Consultation Response from Mark Berry KC, Highways Development Management
2023/92145 East Bierley Playing Fields, Hunsworth Lane, East Bierley, BD4 6PU
Discharge of conditions 5 (access track upgrade), 6 (access track upgrade), 7 (cycle parking), 8 (electric vehicle charging), 9 (travel plan), 10 (waste storage and collection), 11 (coal mining investigation), 16 (Japanese Knotweed strategy), 17 (external lighting), 29 (part) (landscaping) and 30 (biodiversity enhancement and management plan) of previous permission 2021/90357 for works to existing sports facilities including erection of clubhouse; additional changing facilities building; boundary treatments; storage facilities and floodlighting; works to existing pitches creation of hybrid and 3G/synthetic pitches; multi sport training area and car park
Date Responded: 12 th July 2024 Responding Officer: C Dows Responding Ref: K8-7/11

Recommendation – Further Information Required

The submission seeks approval to discharge conditions 5 and 6 of previous permission 2021/90357 for works to existing sports facilities including erection of clubhouse; additional changing facilities building; boundary treatments; storage facilities and f

Drawing Title
Pavements

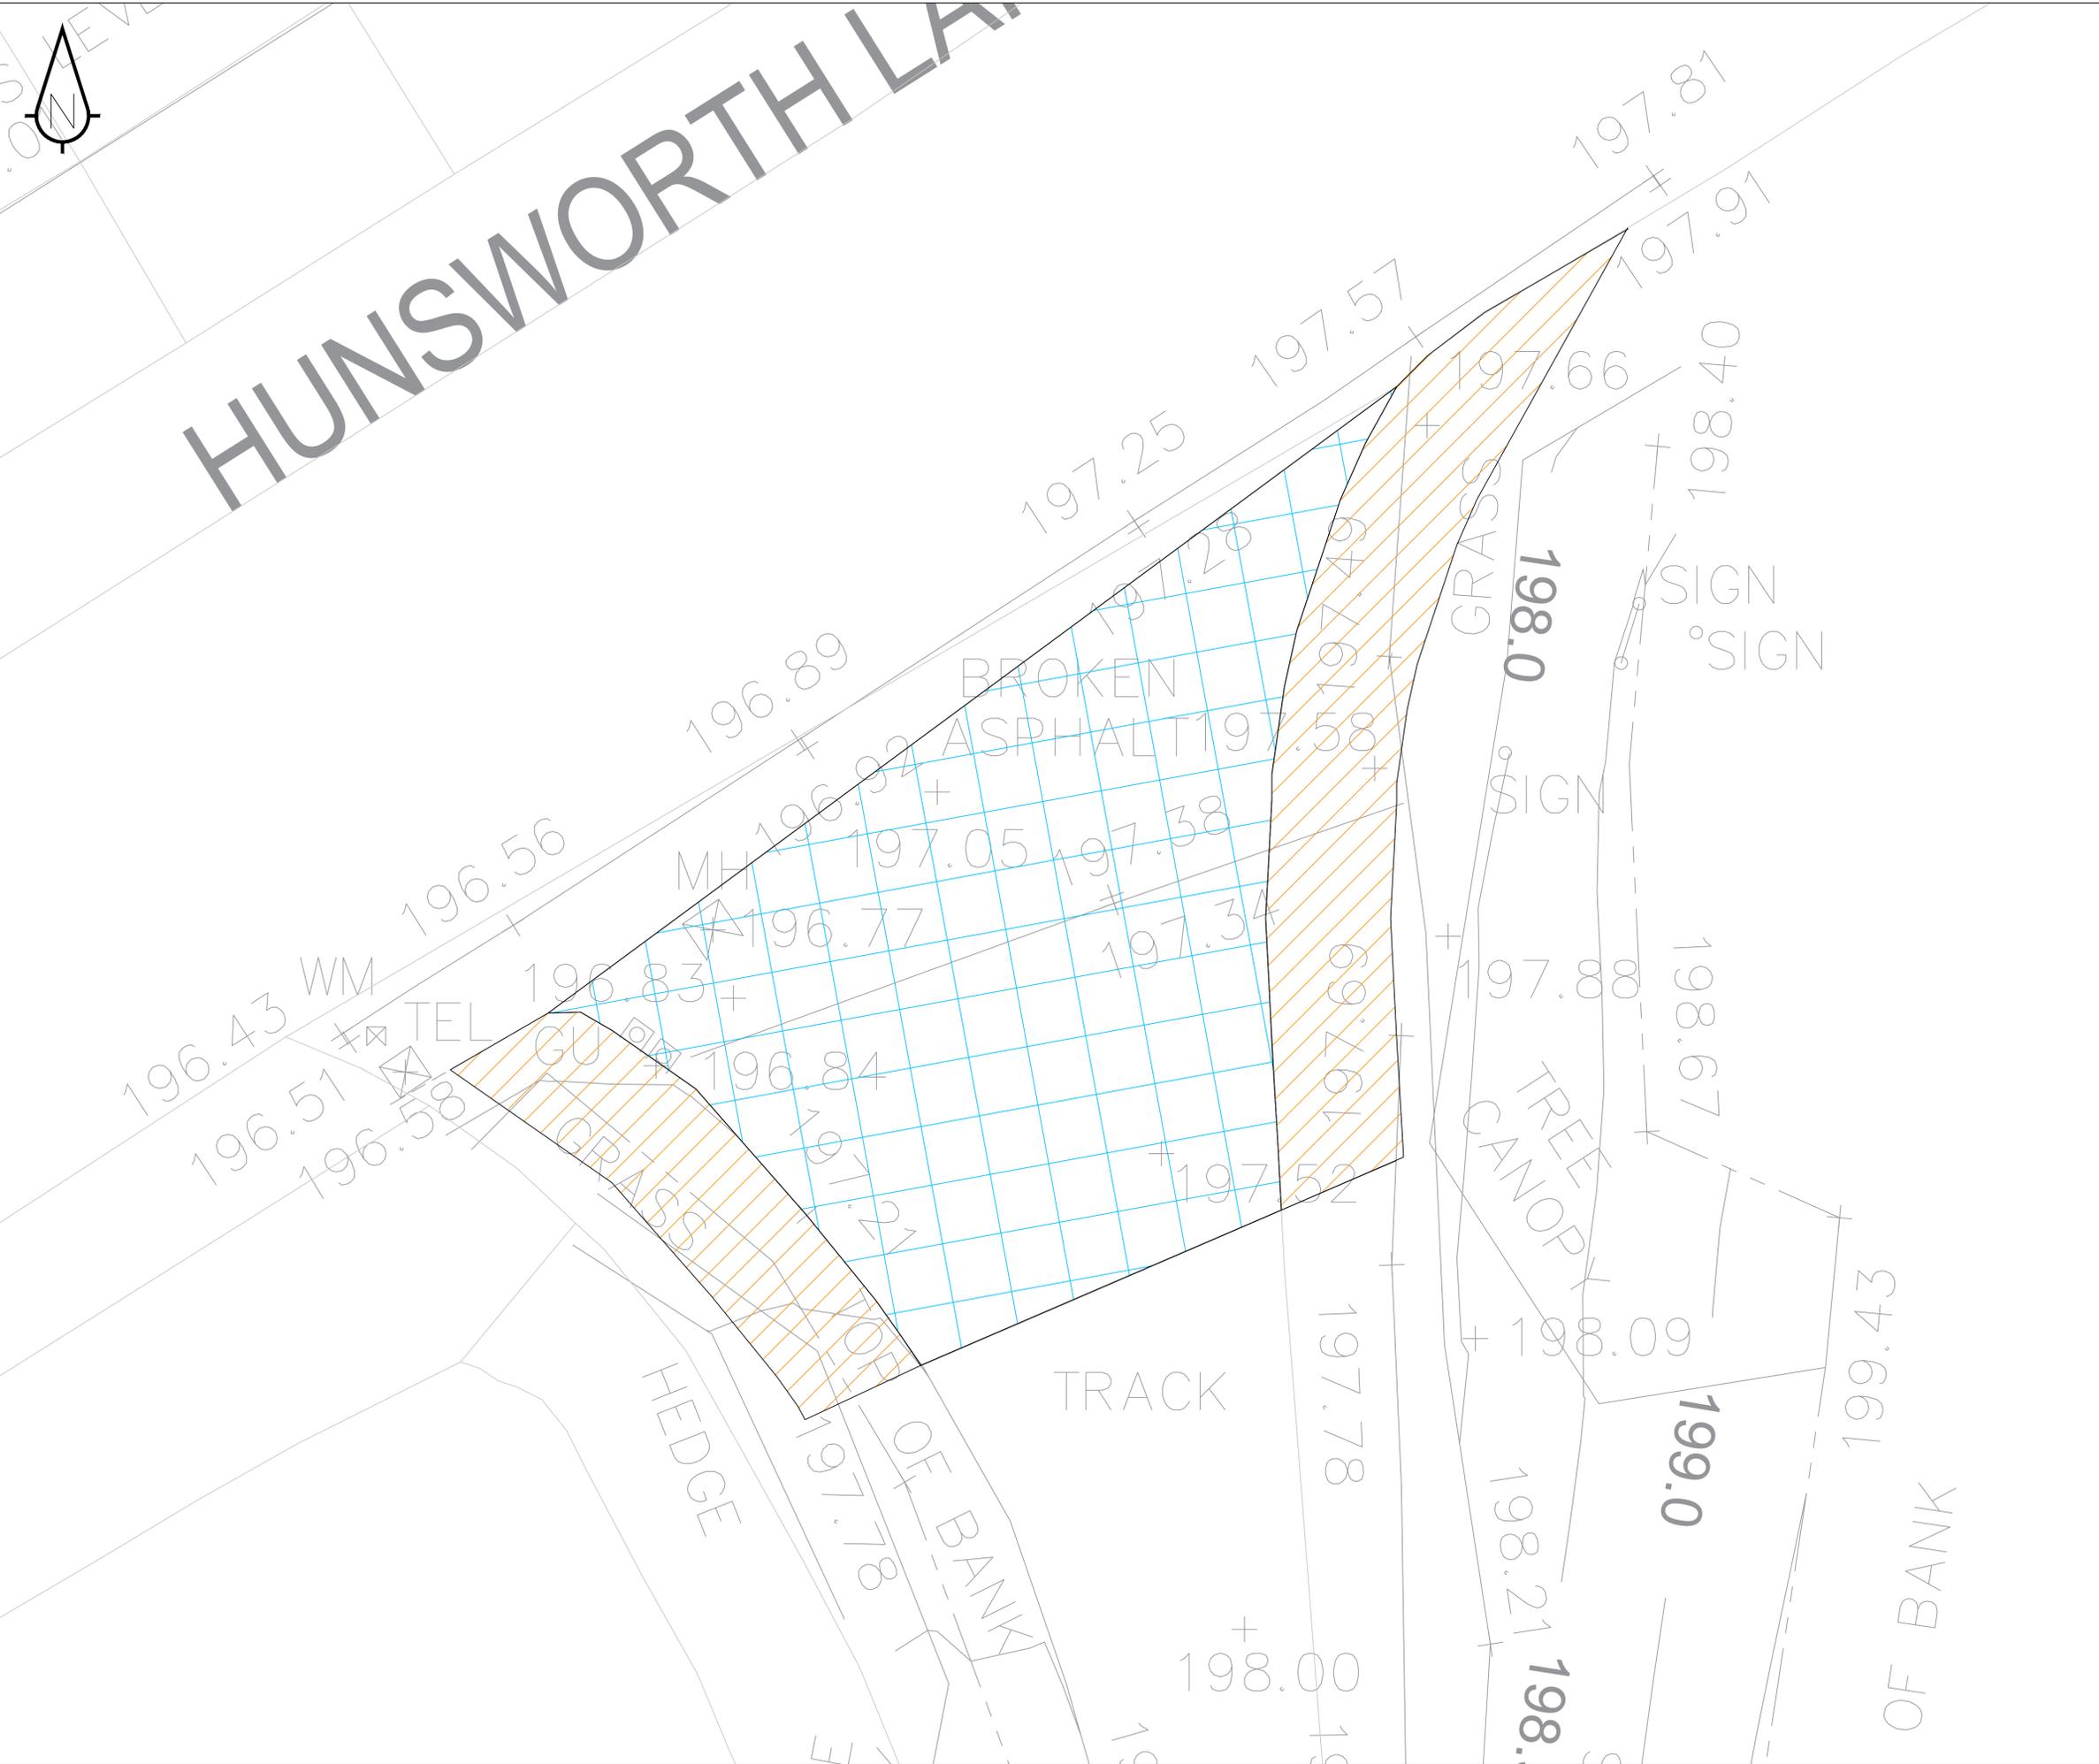
Notwithstanding, the plans submitted have been reviewed and the proposed improvements are considered generally acceptable for the junction/initial length of the access. In terms of construction details Drawing No. 152698-100-C1-0701 - Pavements, refers to Drawing No.152698-C5-0700 for

CBR details, this drawing has not been submitted, similarly Drawing No. 152698-100-C1-1101-Kerbing and Edging Layout, also refers to Drawing No. 152698-C5-0700 for kerb details, for completeness Drawing No. 152698-C5-0700 is required. The submission should include an independent safety audit covering all aspect of the work

- Drawing No. 152698-C5-0700 – showing CBR and kerbing details.
- Details of improvements to the access track beyond initial 10m from junction with Hunsworth Lane.
- Independent safety audit covering all aspects of the work.
